# OBJECTION TO STATE SIGNIFICANT DEVELOPMENT APPLICATION

## Waterloo South Concept SSDA — SSD-93222706

Owners Corporation SP36476 — 110 Wellington Street, Waterloo NSW 2017

| <b>Date</b>           | 29 May 2026   |

Drawing Name
Block 4
Proposed Envelope -
Plan

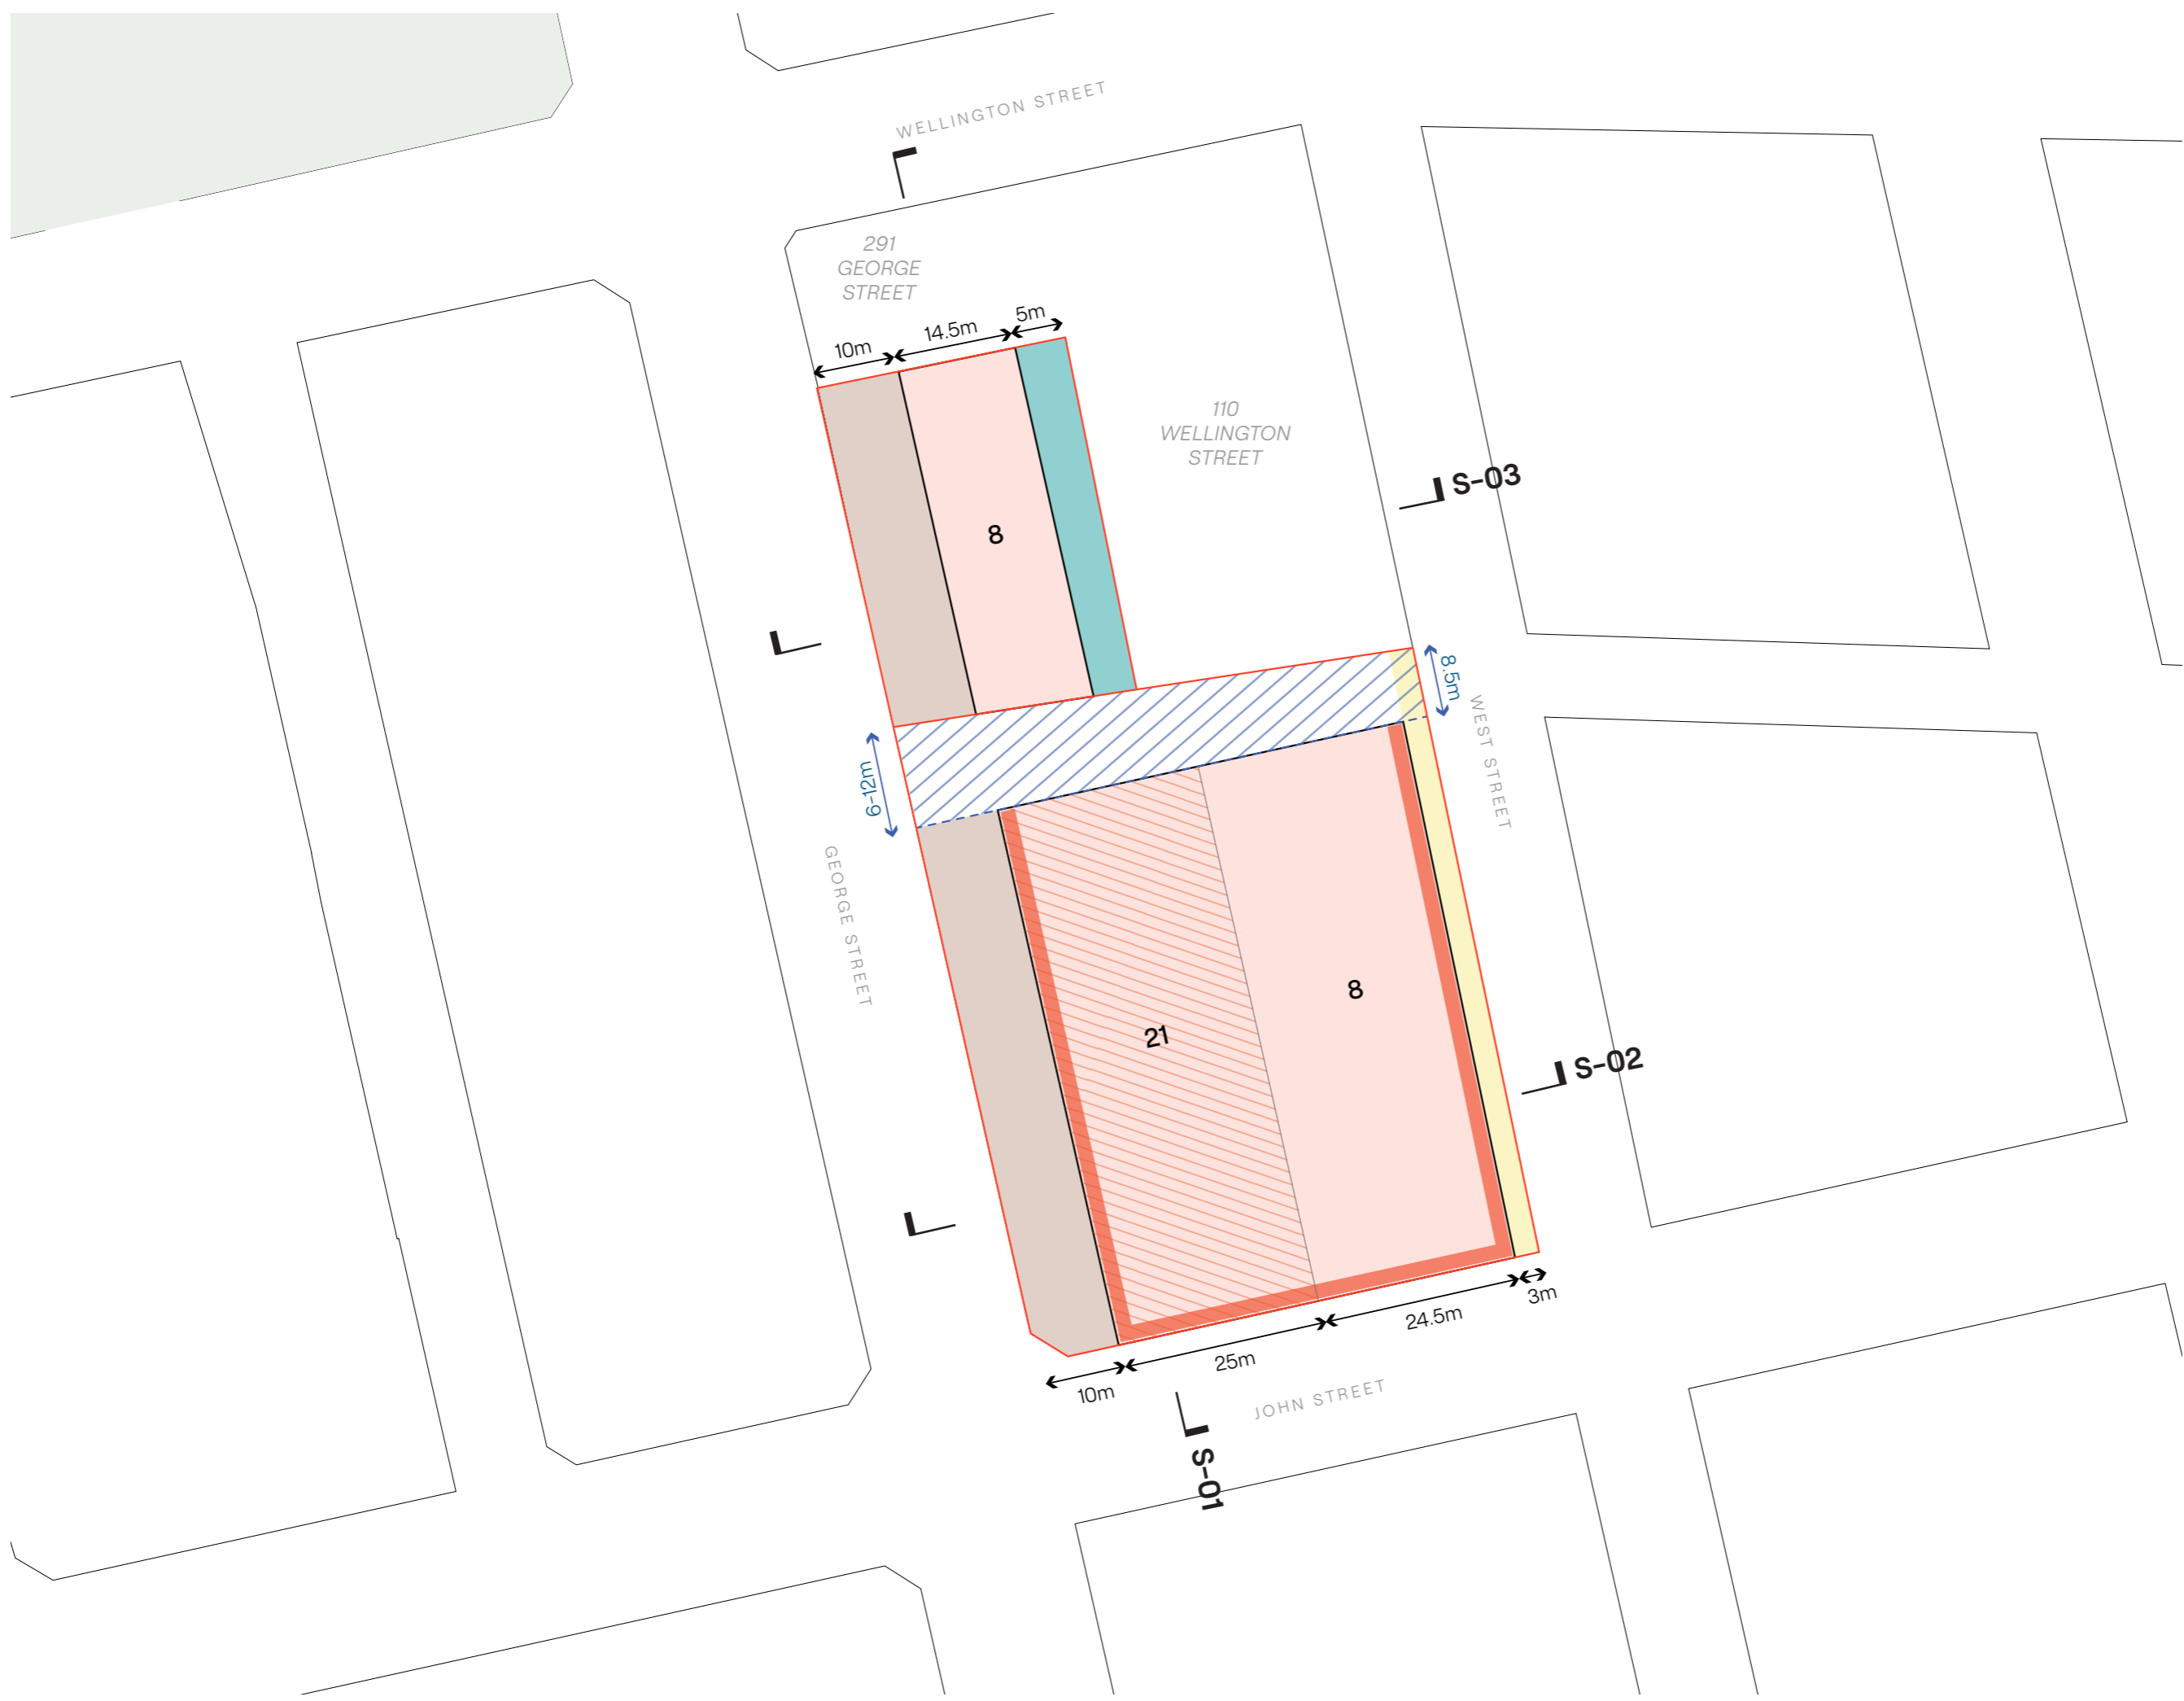
The proposed demolition of the existing George Street social housing, combined with the construction of 4BB1 (8 storeys, RL +40.50m) and 4CB1 (21 storeys, RL +90.50m) on the George Street alignment, will fundamentally transform the solar access conditions for the eastern elevations of 110 Wellington Street. 4CB1 at 21 storeys and RL +90.50m will cast significant shadows over the eastern and upper elevations of 110 Wellington throughout the day, particularly in winter months. This will restrict the solar access of each of the 58 lots, and all common areas of 110 Wellington.

The rear and eastern elevations of 110 Wellington Street will be directly overlooked from multiple upper floors of Block 4 (4BB1 at 8 storeys, 4CB1 at 21 storeys) across George Street, and from Block 5 (5AB1 at 19 storeys) along the Wellington Street frontage. Residents currently enjoy privacy in their balconies and living rooms without awareness of being observed from above or from across the street. The proposed envelopes will place hundreds of dwellings in direct line-of-sight to the private open spaces and habitable rooms of 110 Wellington Street.

No privacy or overlooking assessment has been conducted for 110 Wellington Street or any other privately owned residential building on Wellington Street or the western side of George Street. The ADG separation distance between 4CB1 (21 storeys) and the rear eastern elevation of 110 Wellington has not been assessed or demonstrated to comply.

The demolition of these buildings — which is a prerequisite for the Block 4 development — will remove this buffer entirely and leave 110 Wellington Street with no transitional built form between it and the proposed 8-storey (4BB1) and 21-storey (4CB1) envelopes on George Street. The EIS does not assess the impact of this buffer removal as a discrete and material change in amenity for the residents of 110 Wellington Street.

The proposed Block 4 envelopes (4CB1 at 21 storeys, RL +90.50m) rising immediately adjacent to the Duke of Wellington Hotel on George Street will overwhelm the heritage item and its curtilage. The applicant's own heritage consultant has assessed Design Guide Principle 4 as not being met. The Owners Corporation submits that the visual and contextual impact on the heritage setting of the Duke of Wellington Hotel, and on the low-scale character of Wellington Street, has not been adequately assessed in the EIS Heritage Impact Assessment.

- **Supplementary solar access analysis:** Require the proponent to commission supplementary solar access modelling at hourly intervals between 9am and 3pm for both the winter and summer solstice, specifically modelling overshadowing impacts on 110 Wellington Street and other privately owned properties on Wellington Street and the western side of George Street, in accordance with SEAR 7

- **ADG separation compliance:** Require ADG separation compliance to be demonstrated between 4CB1 (21 storeys, RL +90.50m) and the eastern elevation of 110 Wellington Street

- **Heritage impact assessment:** Require a supplementary Heritage Impact Assessment addressing the visual impact of the Block 4 envelope on the Duke of Wellington Hotel (12085) and the Wellington Street heritage conservation area precinct
- **Independent Planning Commission:** Appoint the Independent Planning Commission as consent authority, given the number of objections received and the contentious nature of this application

Drawing Name
Blocks 5 & 6
 Proposed Envelope -
 Plan

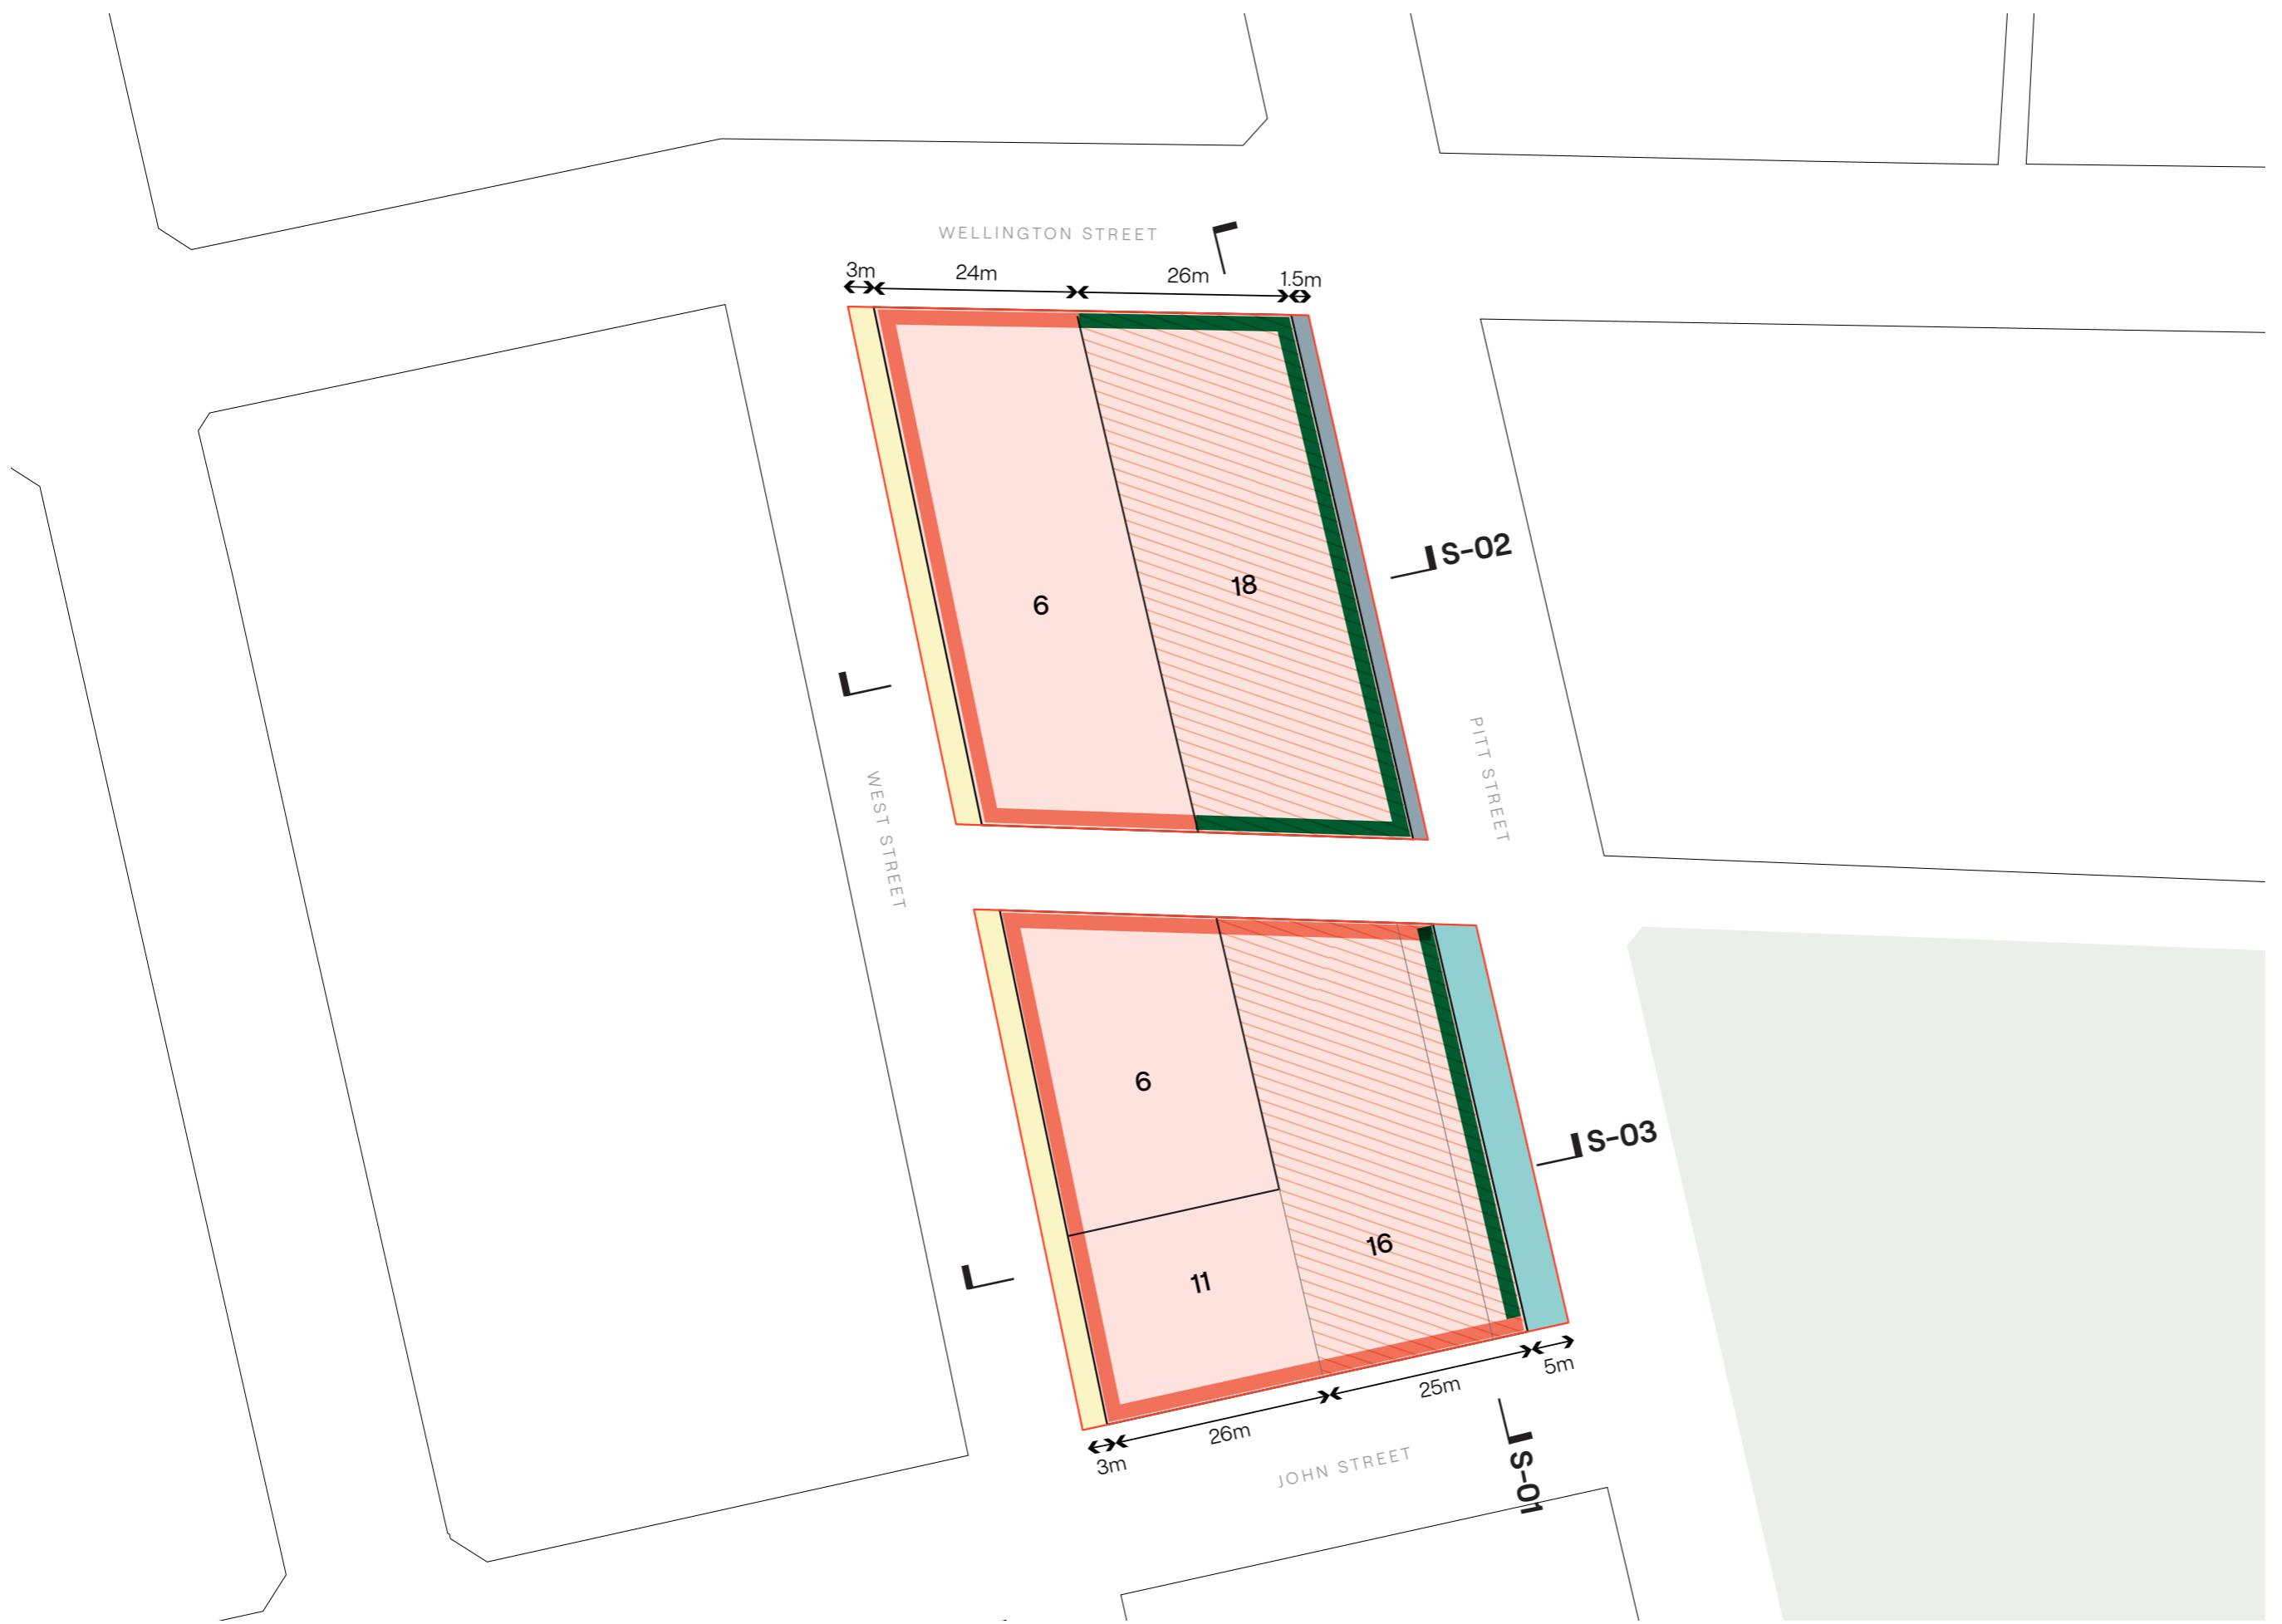
Figure 49 of the EIS (Indicative car park entrances, Updated Waterloo South Design Guide, SJB) identifies multiple carpark entries on West Street, serving Blocks 5 and 6. The EIS also confirms that Block 6's basement is accessed via Block 5, implying consolidated vehicle movements from multiple residential buildings onto West Street. The Design Guide cross-section for West Street (Figure 8(e)) confirms the street is proposed at 14m total width with a 3m travel lane — a width entirely incompatible with the volume and frequency of vehicle movements that will be generated by the carpark entries for two major residential blocks (Blocks 5 and 6) combined with the existing shared-zone pedestrian and cyclist use.

introduce 24-hour vehicle movements — including heavy construction vehicles during the 10–15 year construction programme — onto a street that is currently characterised by quiet shared pedestrian and cyclist activity. No specific pedestrian safety or traffic impact assessment has been conducted for West Street in the context of its use by residents of the privately owned buildings on its boundary.

- **West Street pedestrian safety assessment:** Require a specific pedestrian safety and traffic impact assessment for West Street addressing the conflict between proposed carpark entries for Blocks 5 and 6 and the existing shared pedestrian/cyclist zone, including during construction
